Immingham Green Energy Terminal – TR030008

Section 51 advice regarding draft application documents submitted by Associated British Ports by 23 May 2023

Drawing Number
 GH-20156600001-LP-3

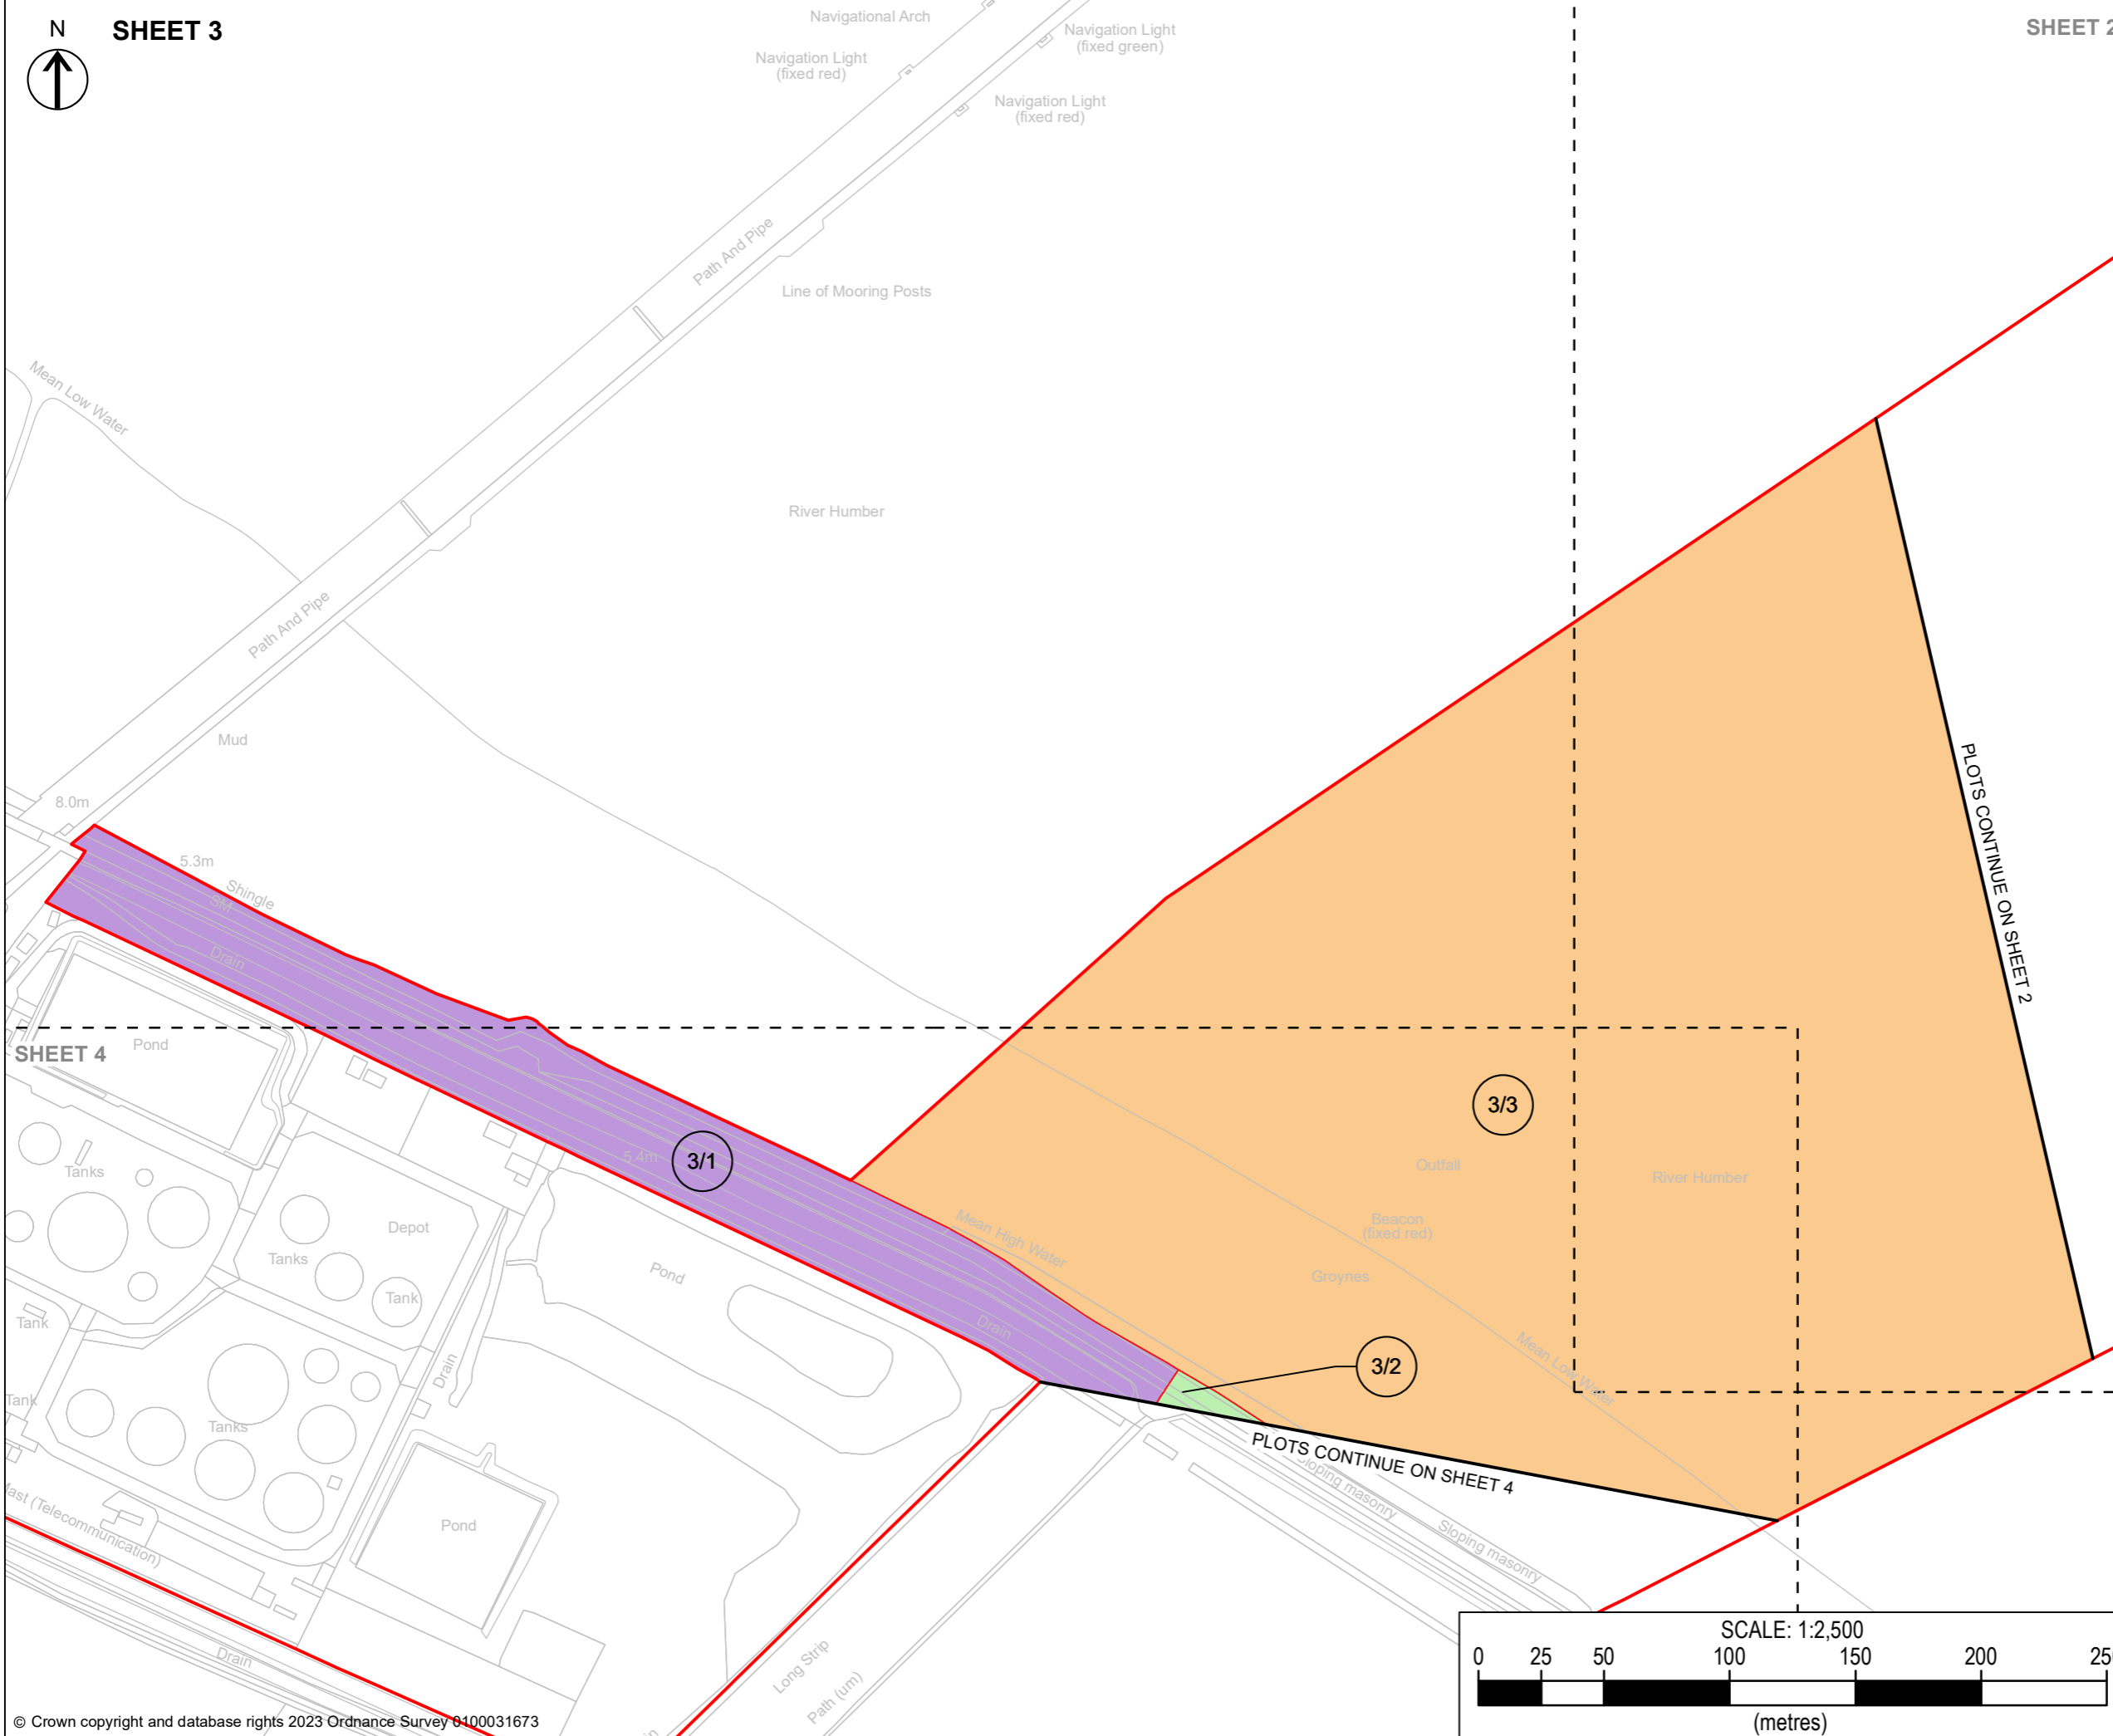
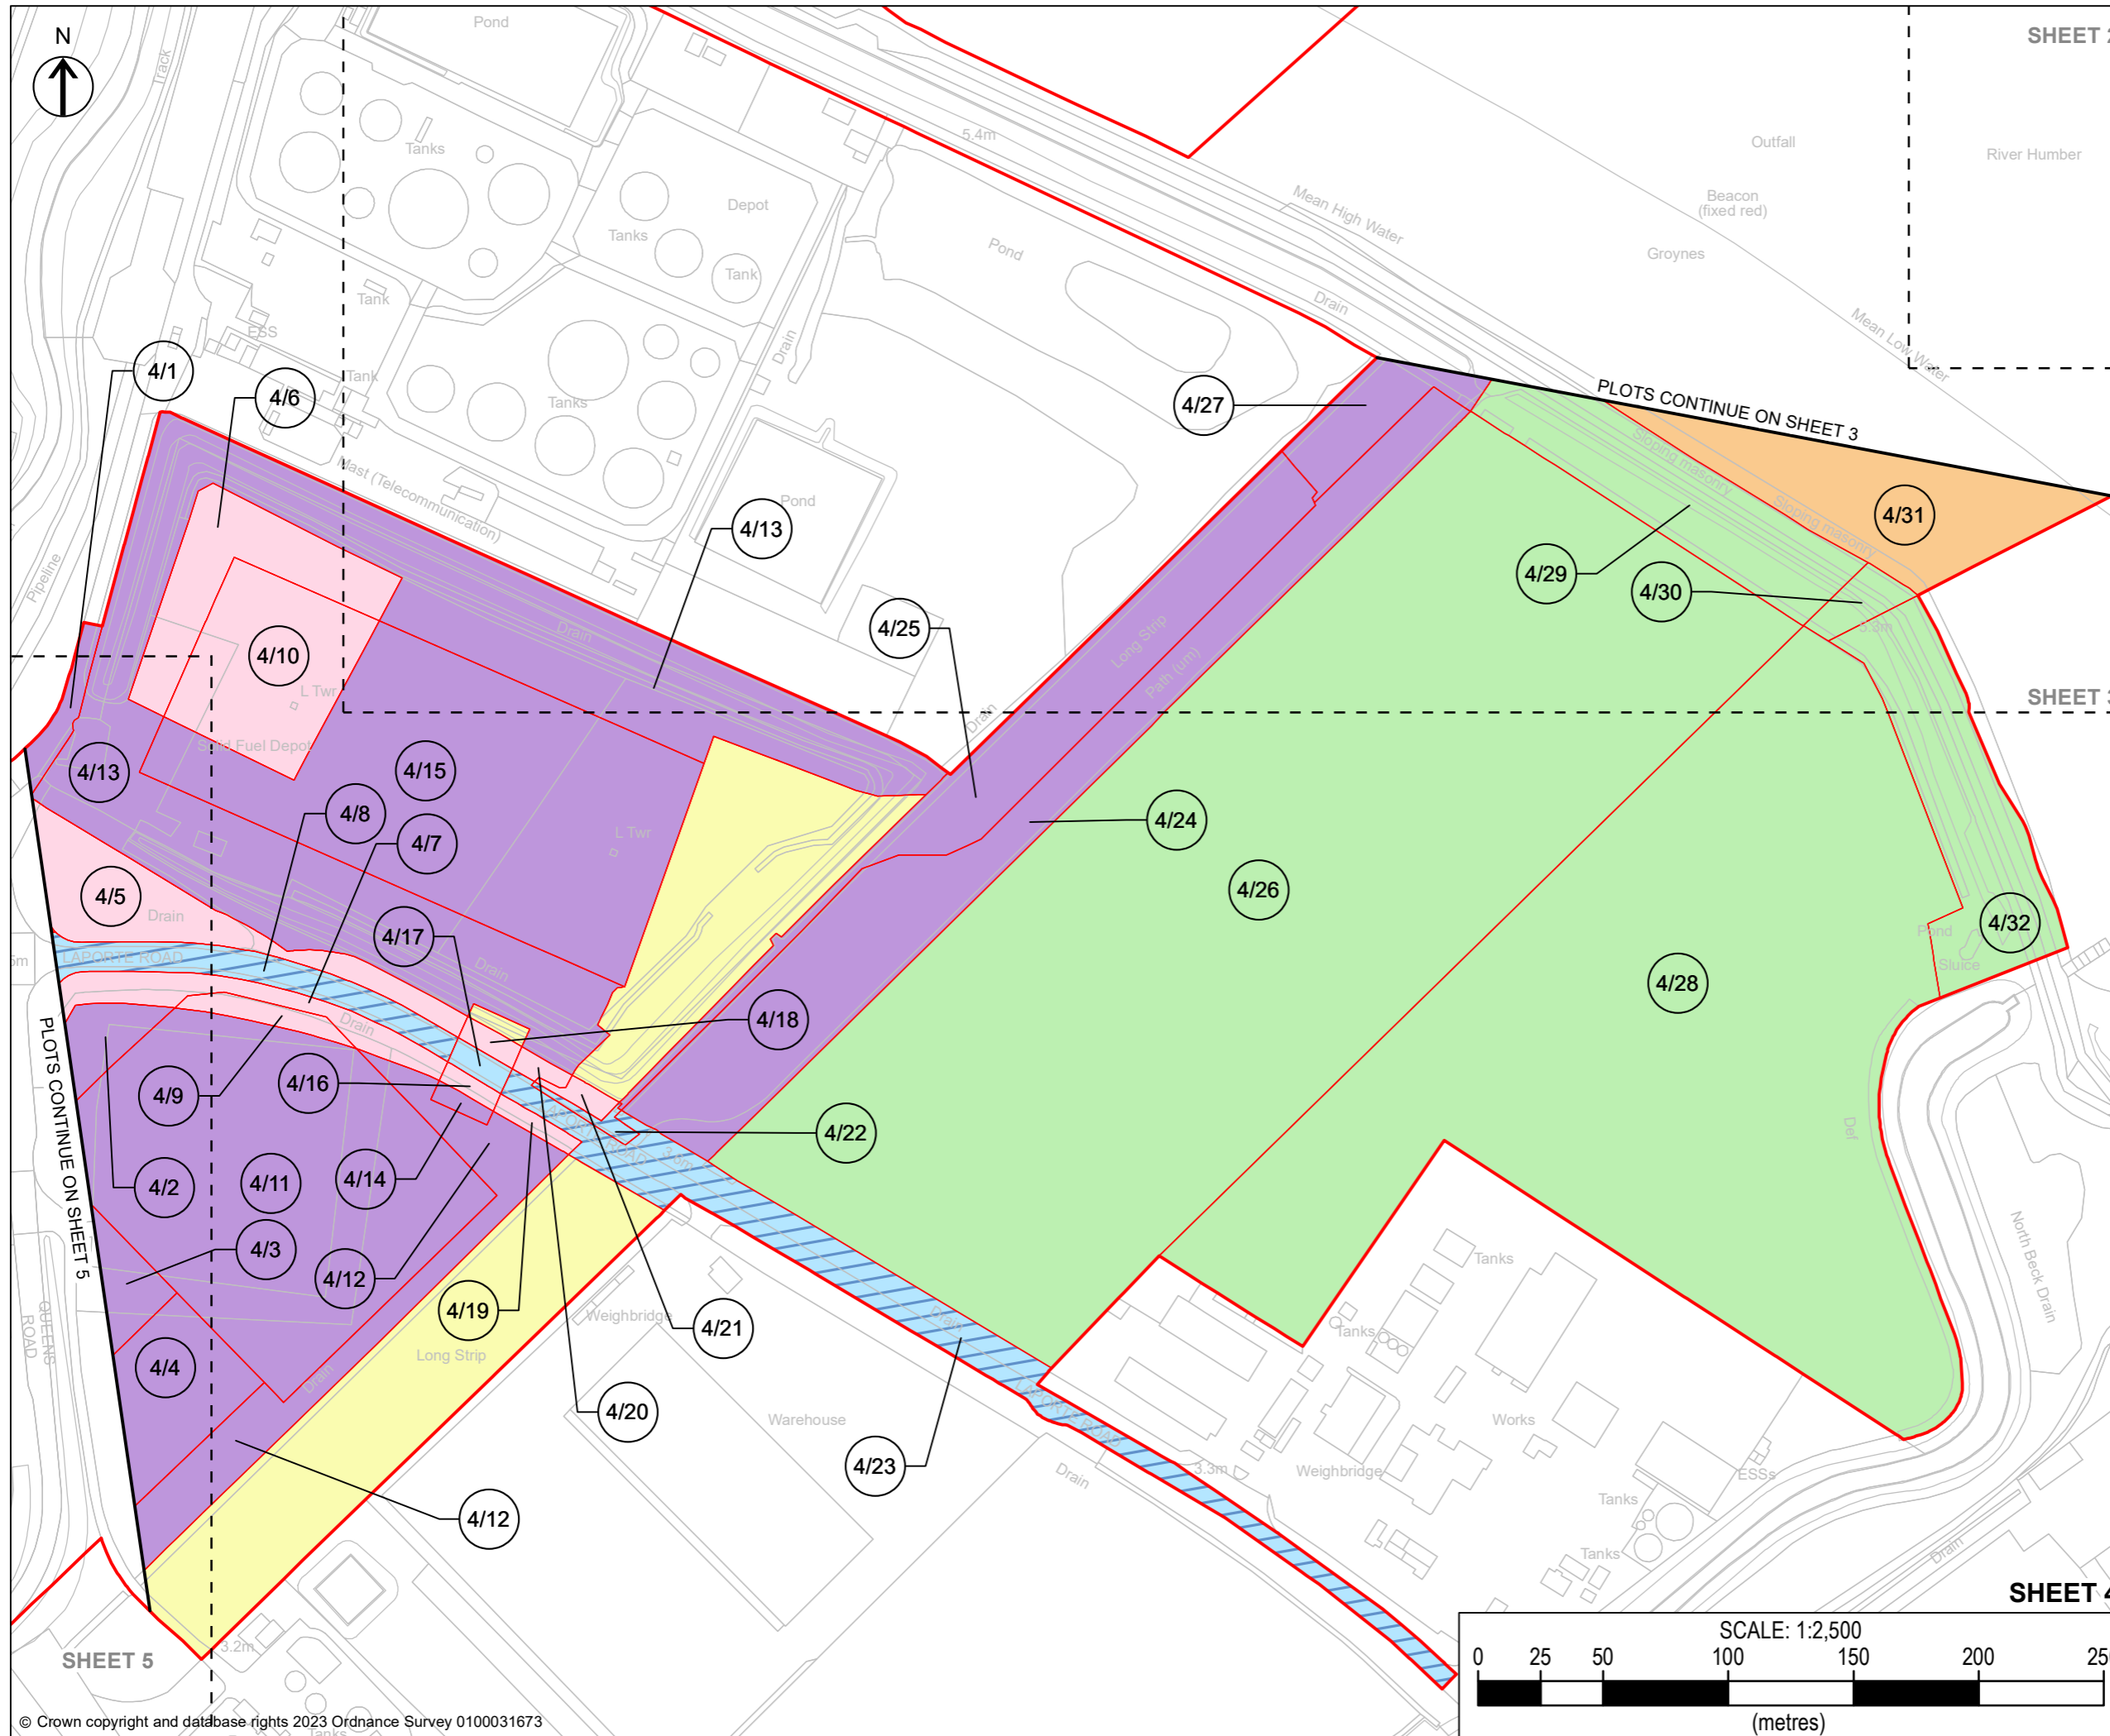
29.	Sheet 3 of 6	<p>Plot 3/1 in the Book of Reference (BoR) describes the land as “...<i>woodland and public bridleway (No.36), (Laporte Road, Immingham)</i>”, however, it appears from Sheet 3 of 6 that plot 3/1 is north-west of Laporte Road. If this plot of land forms part of this Road, the plan may need to be updated to reflect this or vice versa the BoR may need to update its description.</p>

30.	Sheet 3 of 6	<p>Plot 3/26 is identified twice on the Land Plan, which may be in error. The BoR refers to this plot as being part of Laporte Road, however the Land Plan identifies it as part of “Long Strip”. The Applicant may wish to update the Land Plan or the BoR description accordingly.</p>

Land Plans		
Ref No.	Plan ref	Comment/Question
31.	Sheet 3 of 6	The description within the BoR seems to relate to Laporte Road predominately and no other landmarks as identified on the Land Plan. The Applicant may wish to update the land plan or BoR description accordingly.
